Attachment A

ISSUES	RESPONSE
NSW Department of Planning	
<p>The Proponent is required to:</p> <ul style="list-style-type: none"> provide information on the arrangements for containing contaminated fire fighting water in the case of a fire involving inks; update the base leak frequency information based on the size of valves to which the information applies, and provide clarification on if the frequency used was total frequency or specific for a certain size; and undertake a revised risk assessment of fire in the toluene storage bund in the event of a leak or rupture of a storage tank. 	<p>Section 2.1 of the Response to Submissions and the letter prepared by Sherpa Consulting (see Attachment B) demonstrates that the potential hazards identified in the Department's letter can be adequately addressed.</p>
<p>The Department has requested the Proponent to quantify the proposed reduction in greenhouse gas emissions that would be achieved by the proposed energy efficiency measures.</p>	<p>See Section 2.2 of the Response to Submissions.</p>

**IPMG
SCRIVENER STREET RENOVATION
AND WAREHOUSE EXTENSION
SITE PLAN**

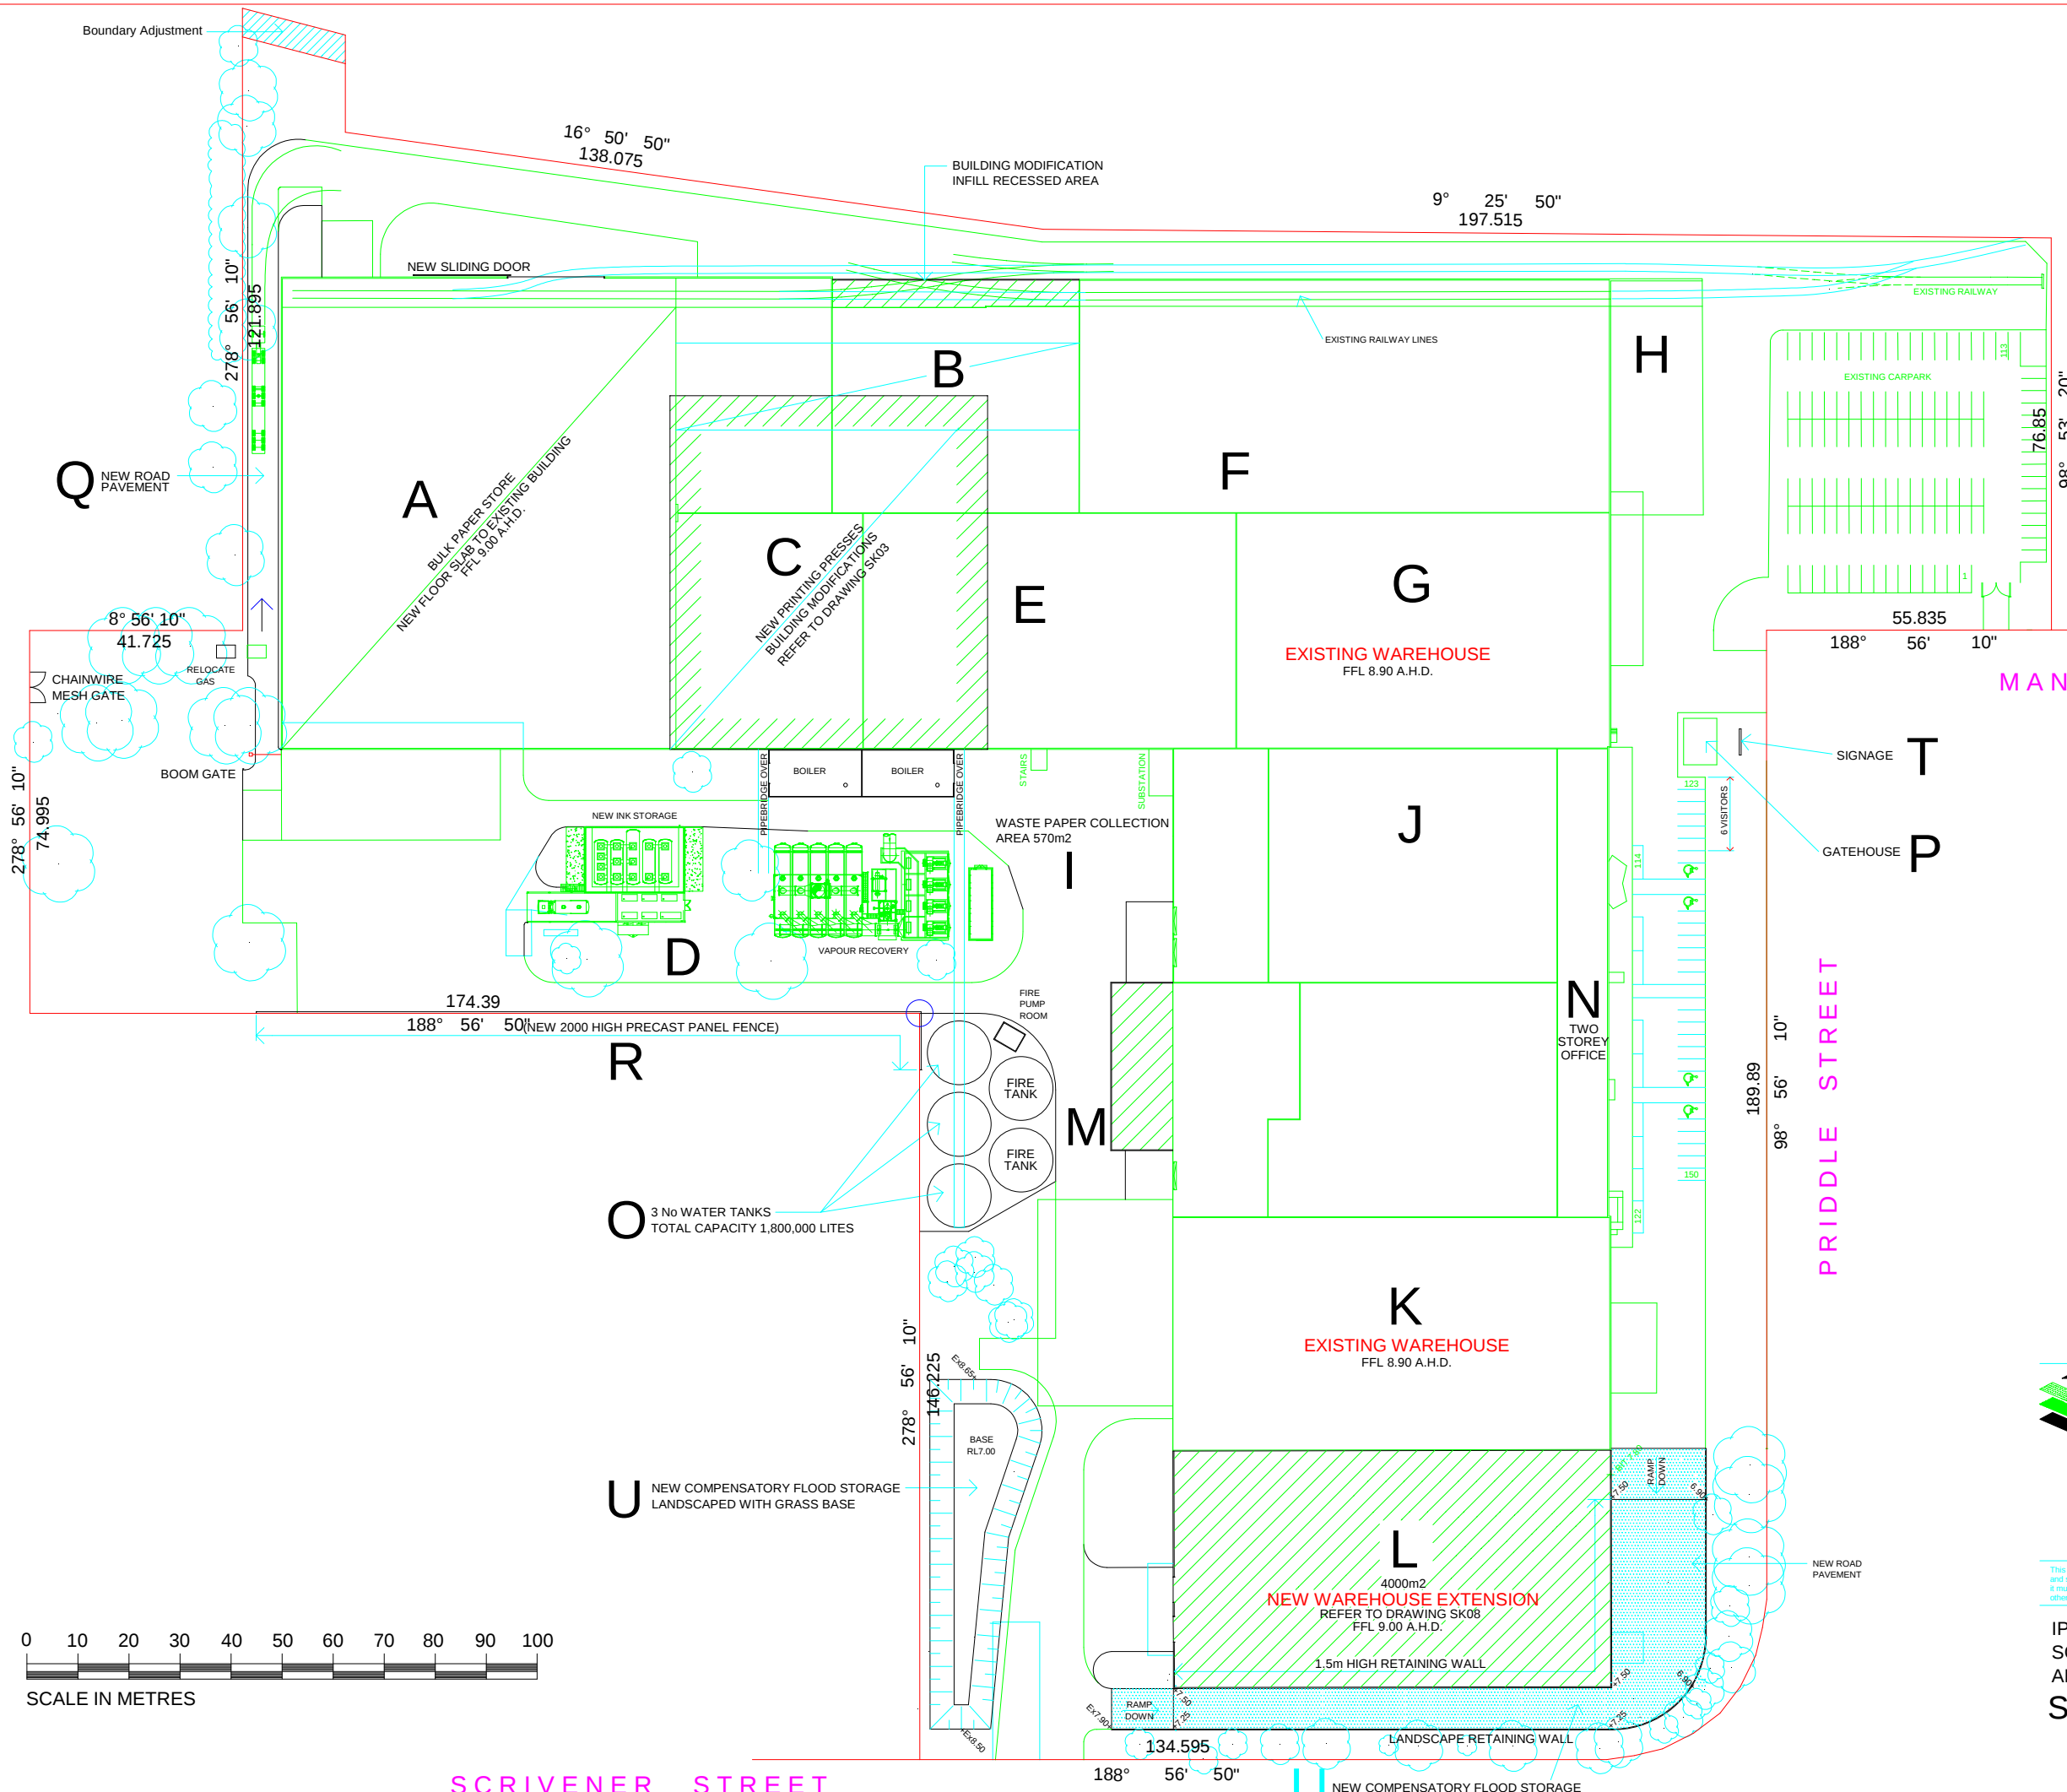
Sydney Regional Development Advisory Committee (SRDAC)	
<ul style="list-style-type: none"> ▪ The proposed initiatives to encourage employee use of public transport are commended. 	<p>Noted.</p>
<ul style="list-style-type: none"> ▪ The plans submitted with the application do not provide details of the car parking and loading areas and therefore a detailed assessment of the internal arrangements could not be undertaken. 	<p>Noted. Plans detailing the car parking and loading areas were submitted with the application and are appended to Appendix M of the EAR.</p>
